MEMORANDUM

To: FILE
From: Nell Donaldson
Subject: Application ID: 2015-169
Date: 10/28/2015

SITE PLAN

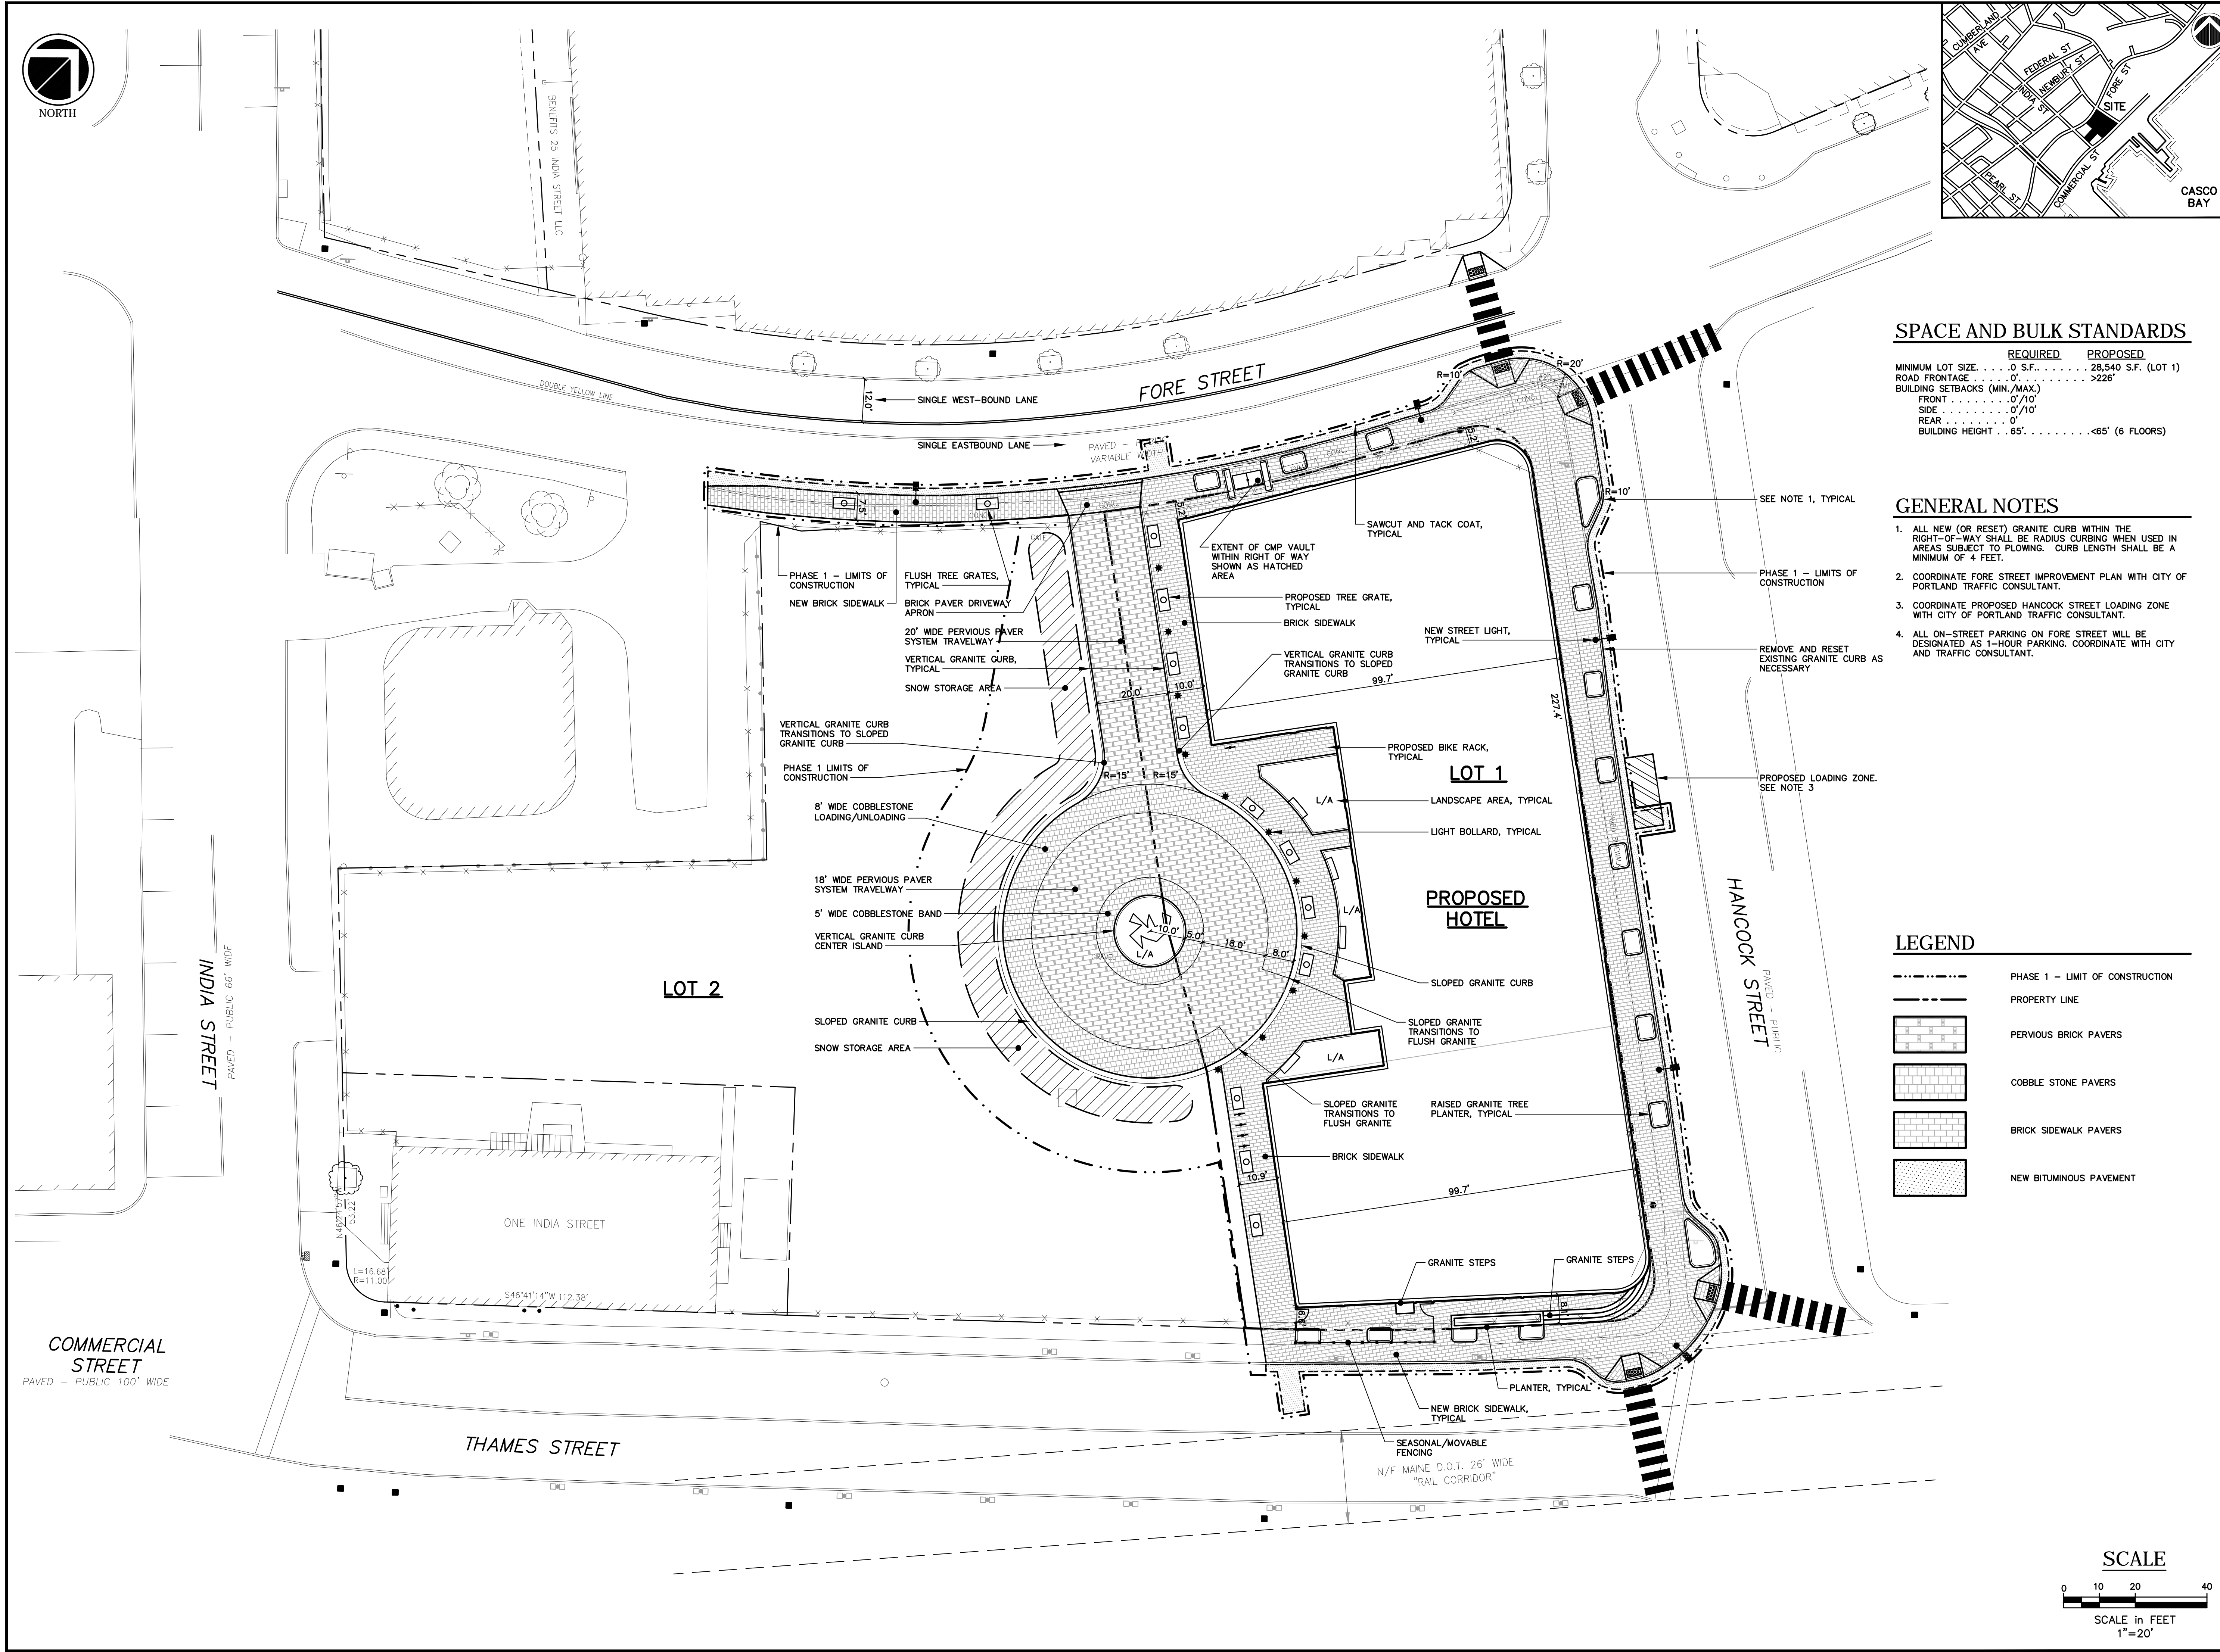
Access looks great to 4 sides of the Hotel. Access off of Thames, Hancock and Fore are more than adequate in addition to use of the drive-up circle for the front of the structure.

Would like to see an analysis of the existing hydrants in the immediate area.

2009 NFPA 1 18.3 Water Supplies and Fire Hydrants
